From: Charlotte Burrows on behalf of Planning.Responses
Sent: 04 September 2017 10:56
To: Planning Scanning
Subject: FW: AW/208/17/HH 31 Queens Fields West, Aldwick

From: Richard Temple <Richard.Temple@arun.gov.uk>
To: [REDACTED]
Sent: Thursday, 24 August 2017, 16:08
Subject: AW/208/17/HH 31 Queens Fields West, Aldwick

Proposed Elevations

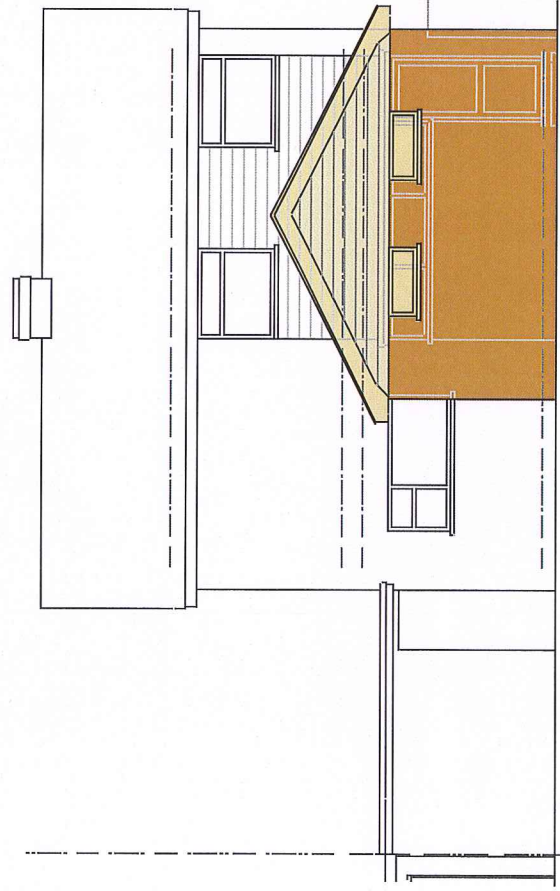
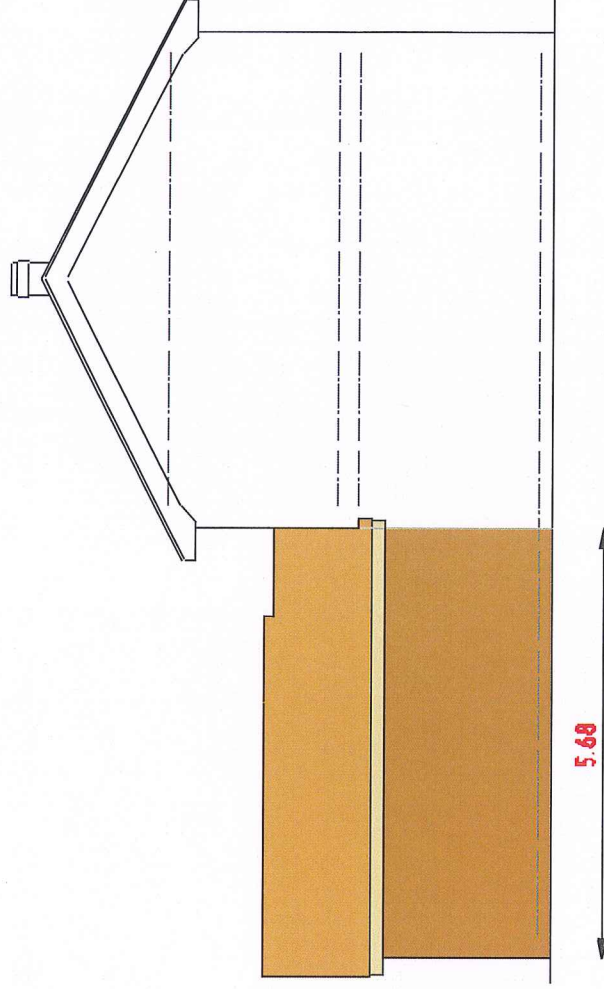
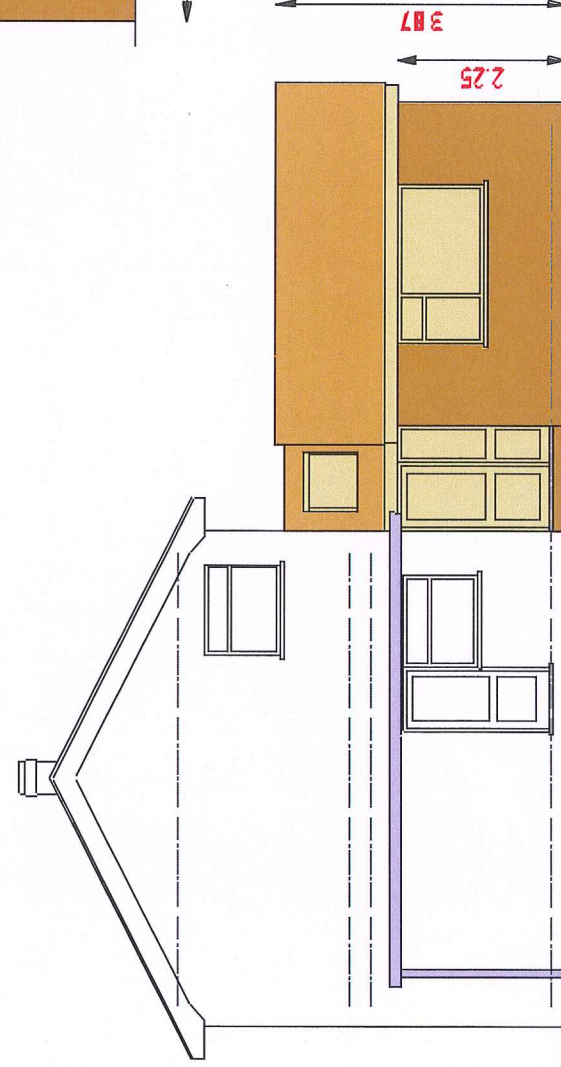
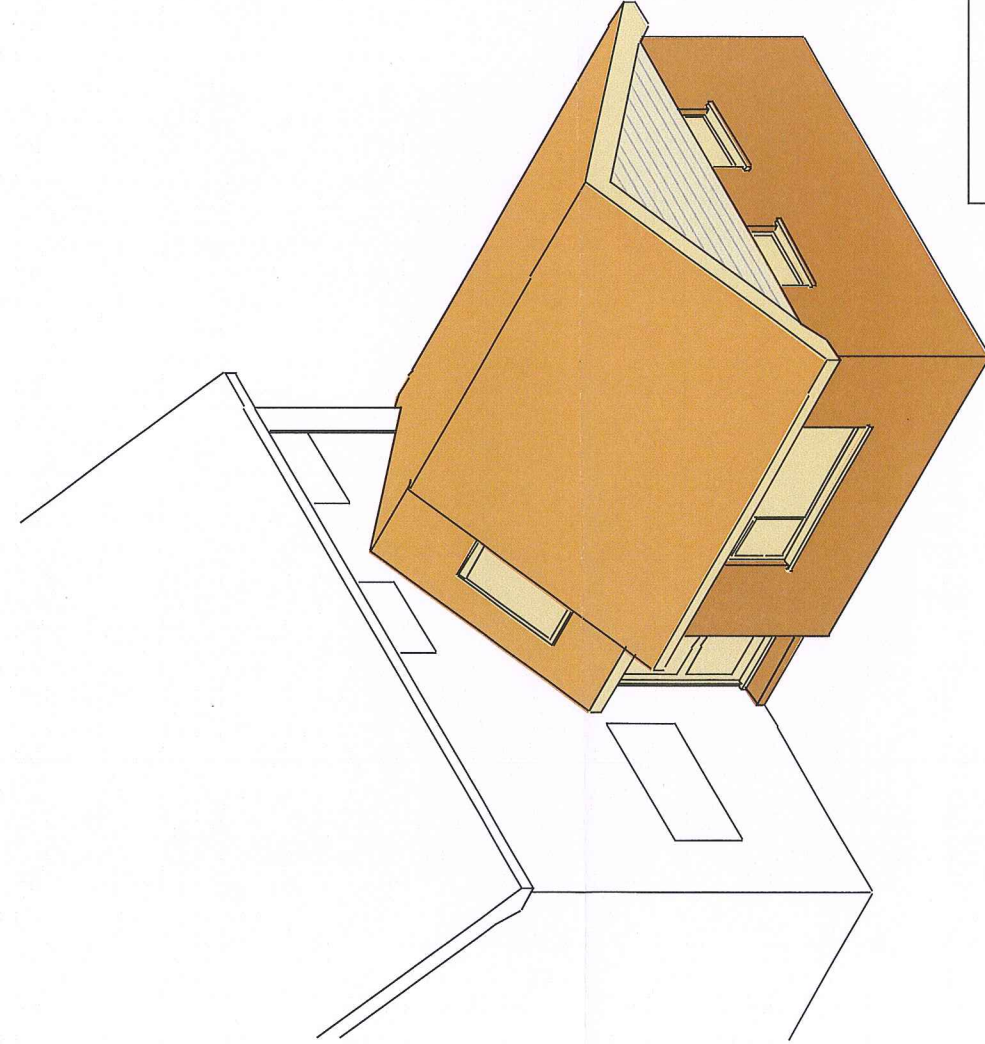
I have made a site visit and been able to assess the application. As it currently stands the application is considered to be unacceptable on design grounds. Front extensions are not a common feature of the area and the proposal is considered to be damaging to the appearance of the dwelling and prevailing pattern of development in the area. As such the application would be refused on those grounds as it is contrary to saved policies GEN7 & DEV19 of the Arun District Local Plan and the Aldwick Parish Design Statement.
